From: Simon Davis
Sent: 11 June 2019 12:22
To: Angus Eitel [REDACTED]
Subject: RE: BN/12/19/PL The Cottage Piggeries - Changes to Replacement Dwelling.

Proposed Roof Plan

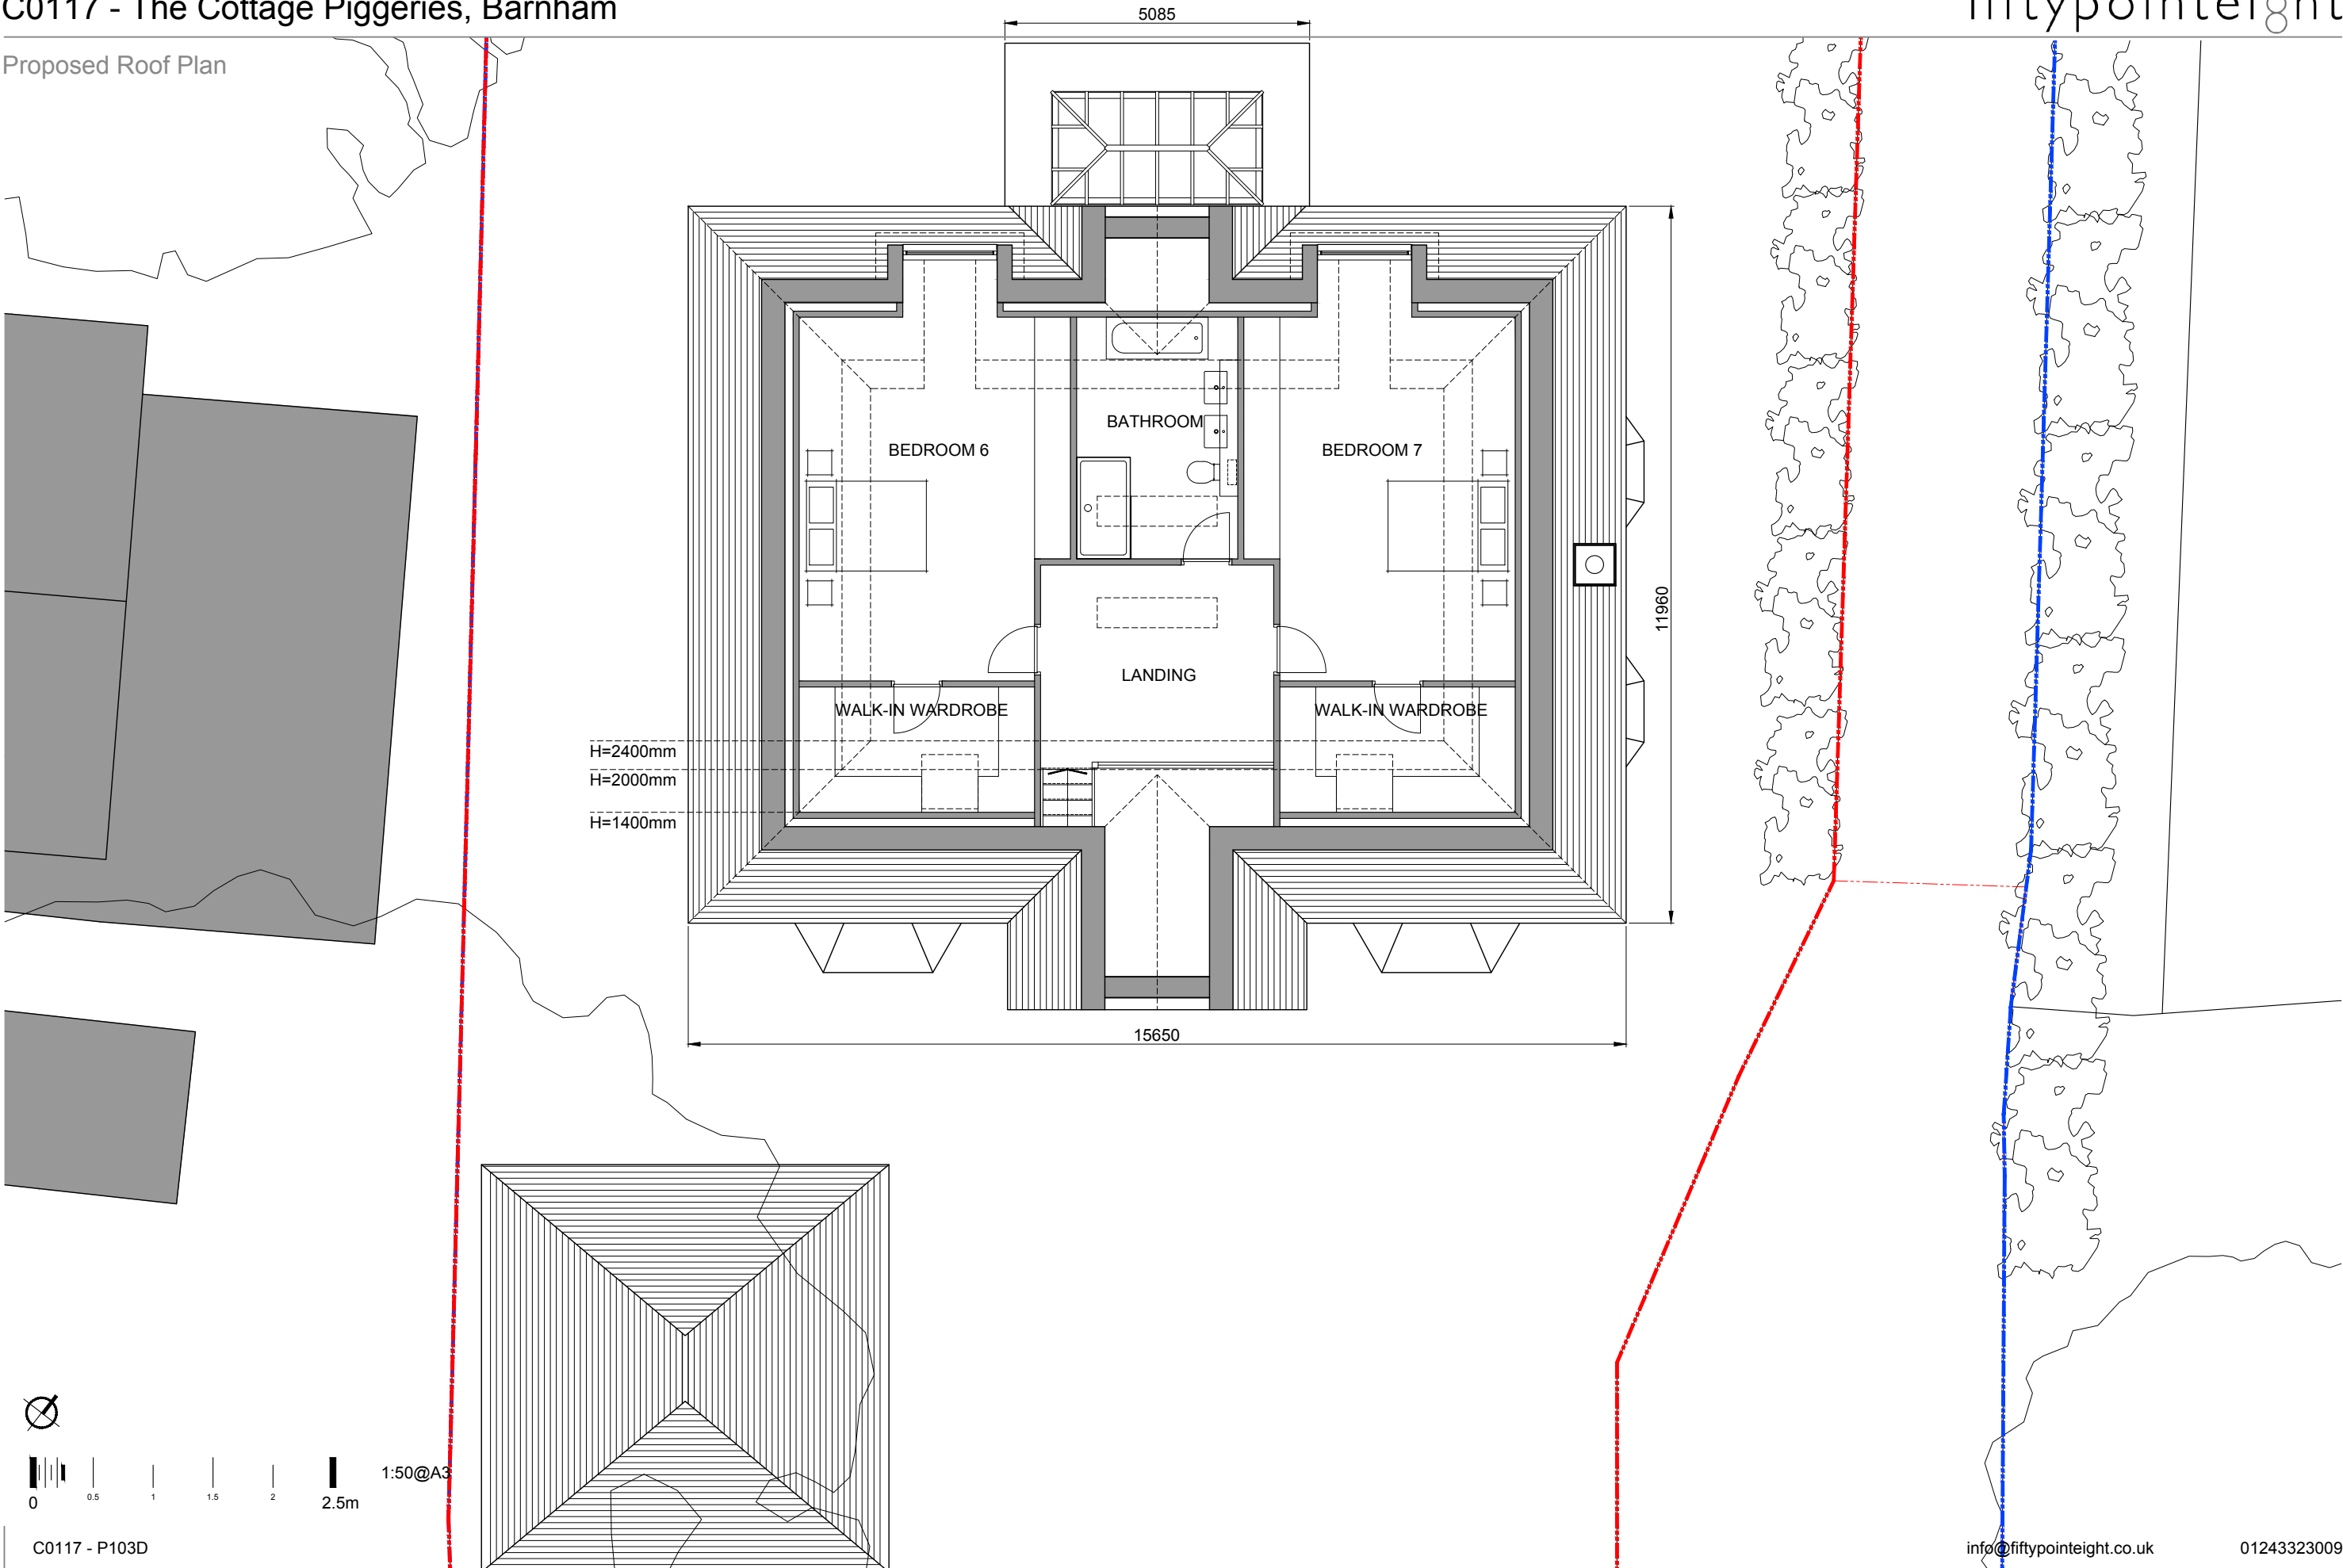
I have spoken with Albert this morning and I said that I would have a think about how we are likely to recommend BN/12/19/PL for the additional accommodation in the roof. I have duly looked at the plans and consider it likely that we will recommend approval. At the present time this will be a delegated decision but this could change if we get a response from the Parish Council. Can you provide me with a cross section of the proposed roof level accommodation so that I can check the heights of the velux windows. Subject to this, we may or may not need to impose an obscure glazing condition on these two velux windows.

Proposed section attached, showing heights at velux positions.

We are comfortable with a condition imposing obscured glazing on the two veluxes.
